### ABLE MARINE ENERGY PARK (Material Change 2 – TR030006)

## **Proposed Able Marine Energy Park (AMEP) Quay Material Change 2 Application**

**Case Reference: TR030006**

**March 2021**

Project: ABLE Marine Energy Park  
 Client: ABLE UK Limited  
 Drawing Title: Section A for Quay Typical Section

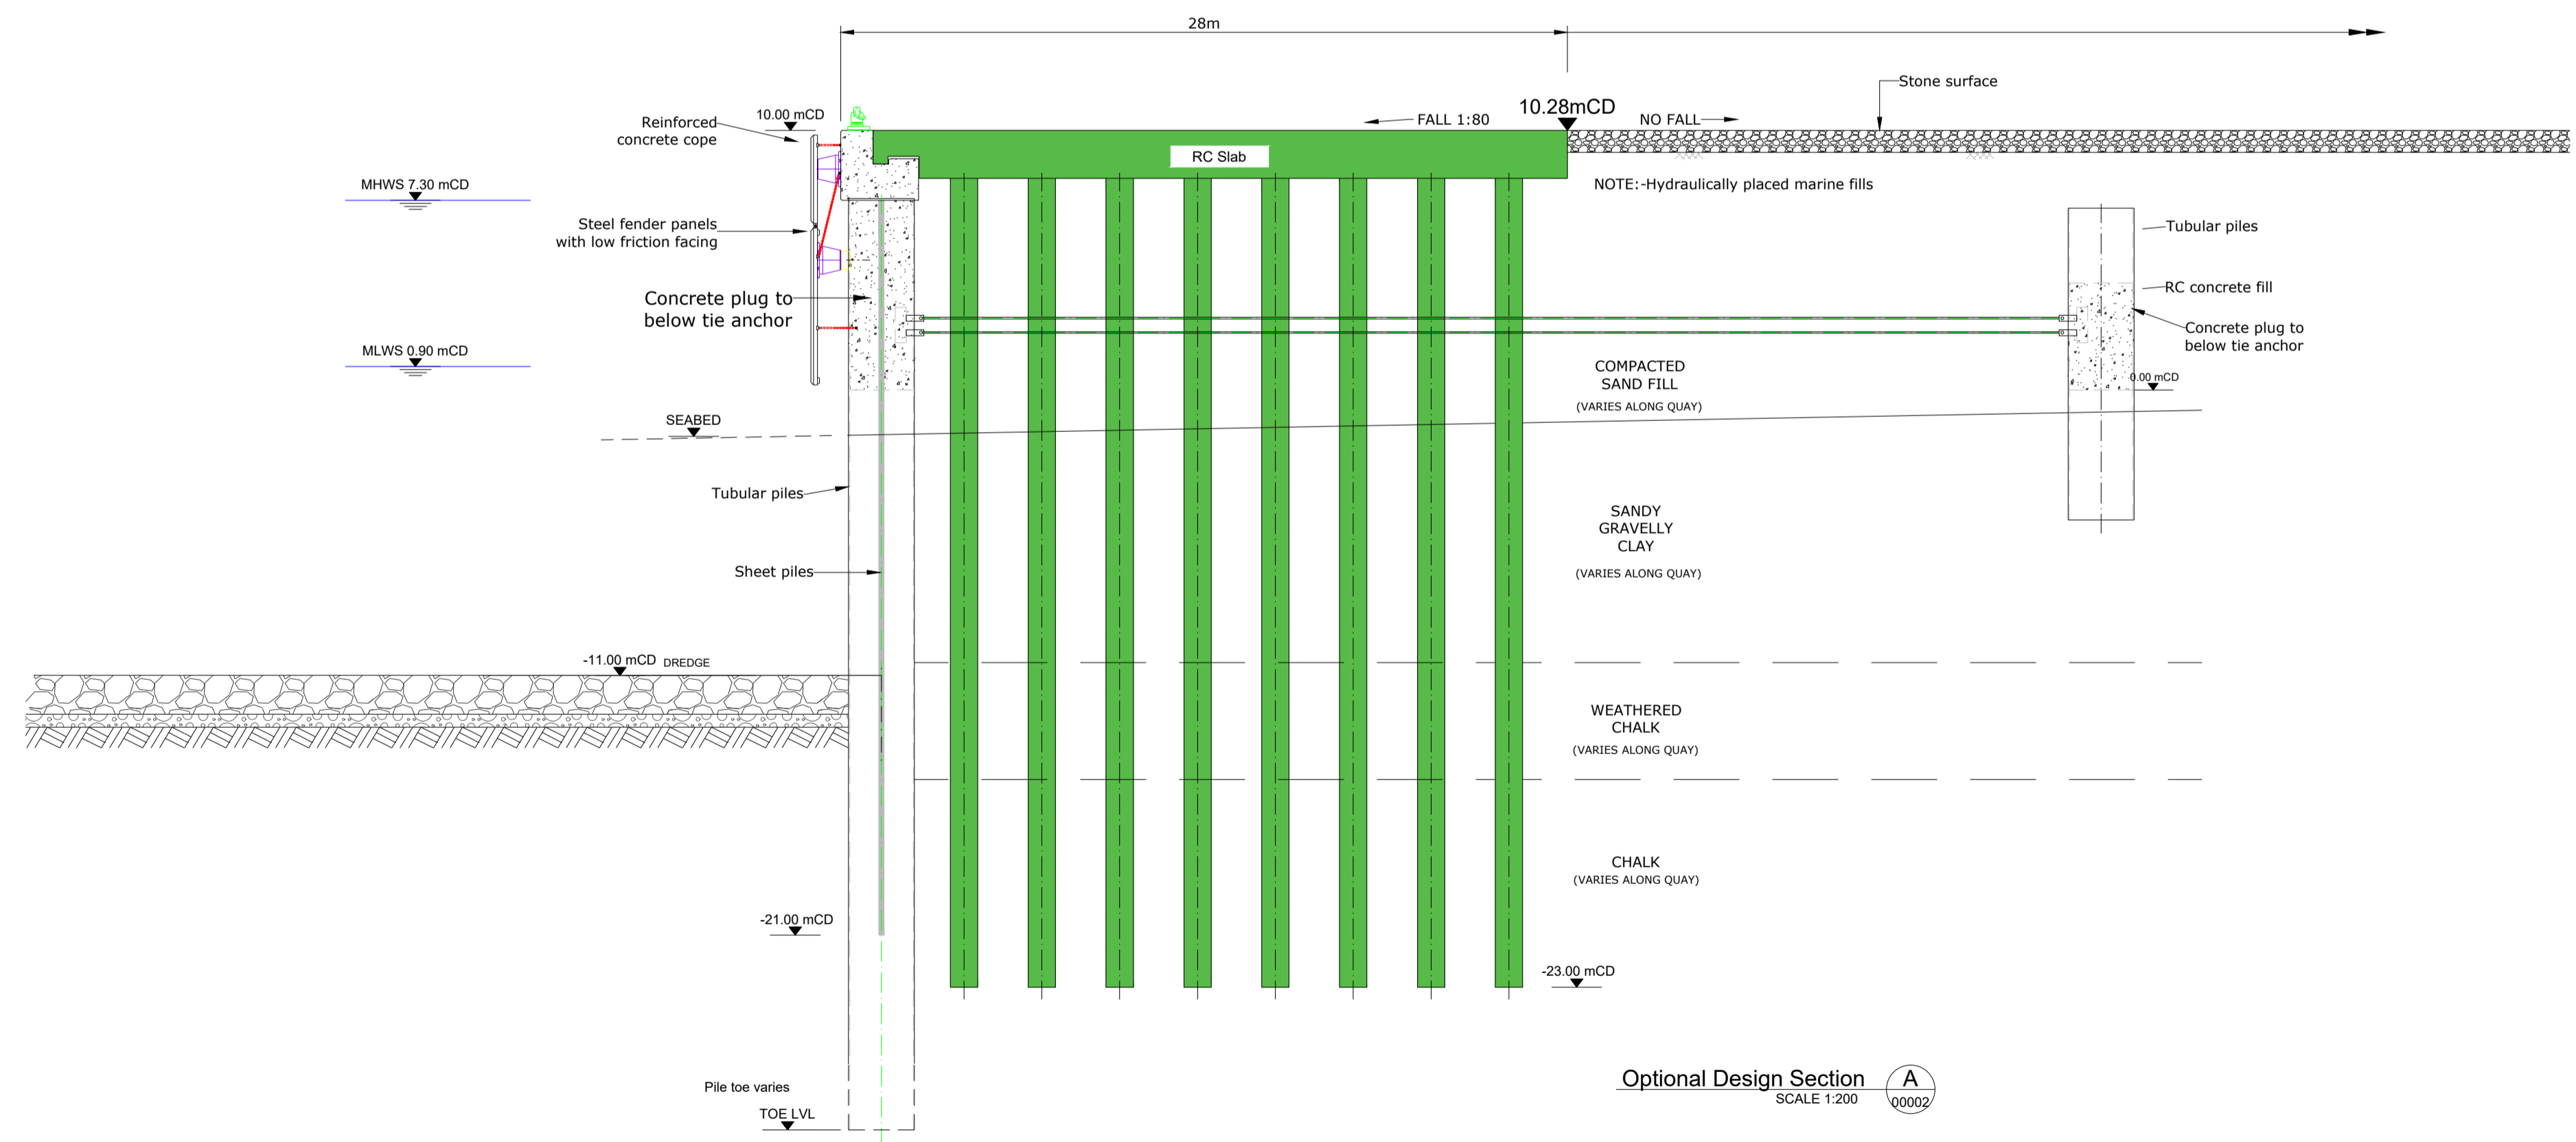
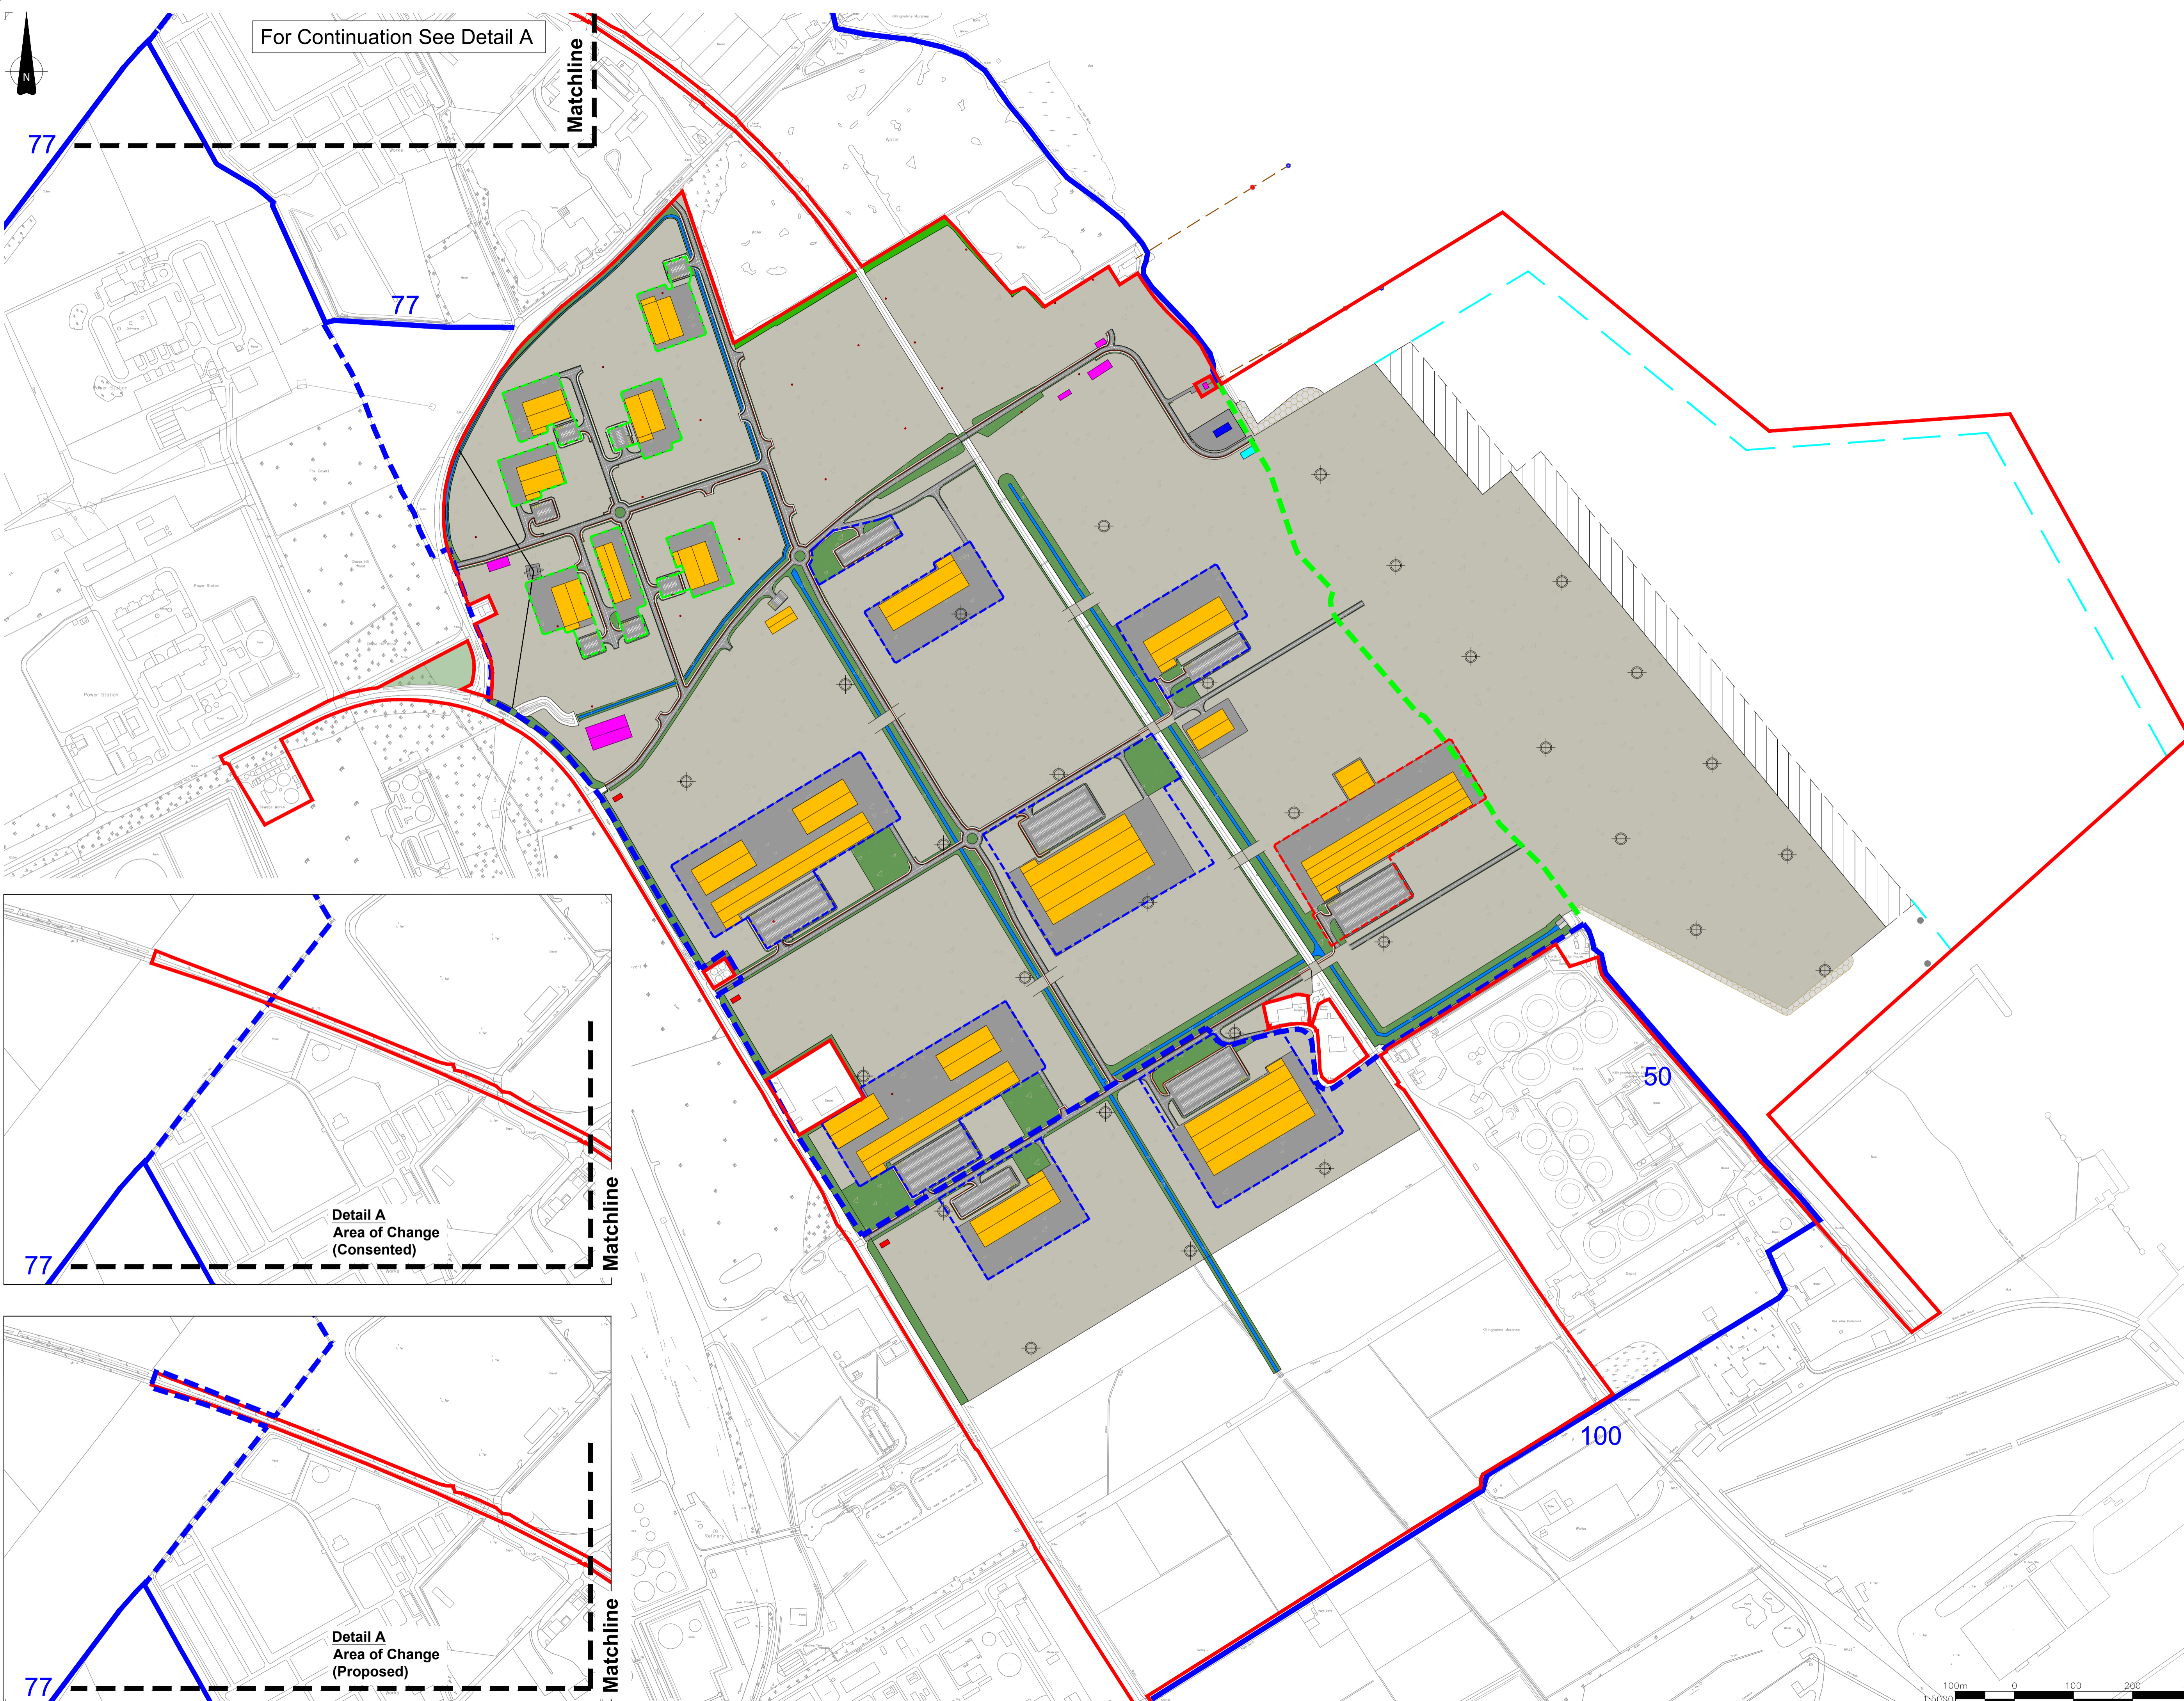
- 2.3.5 The Inspectorate notes that regarding the marine area of the development, that Piling works are already subject to the approval of a method statement (Schedule 8 paragraph 37), and that greater flexibility is now sought in regards to that approved in (Schedule 8 paragraph 4(1)(c)) which would enable either flap anchors or anchor piles with tie rods, and greater diameter front wall piles

to be used, subject to detailed design. The updated ES should provide describe the main alternatives considered and the reasons for selecting the final design.
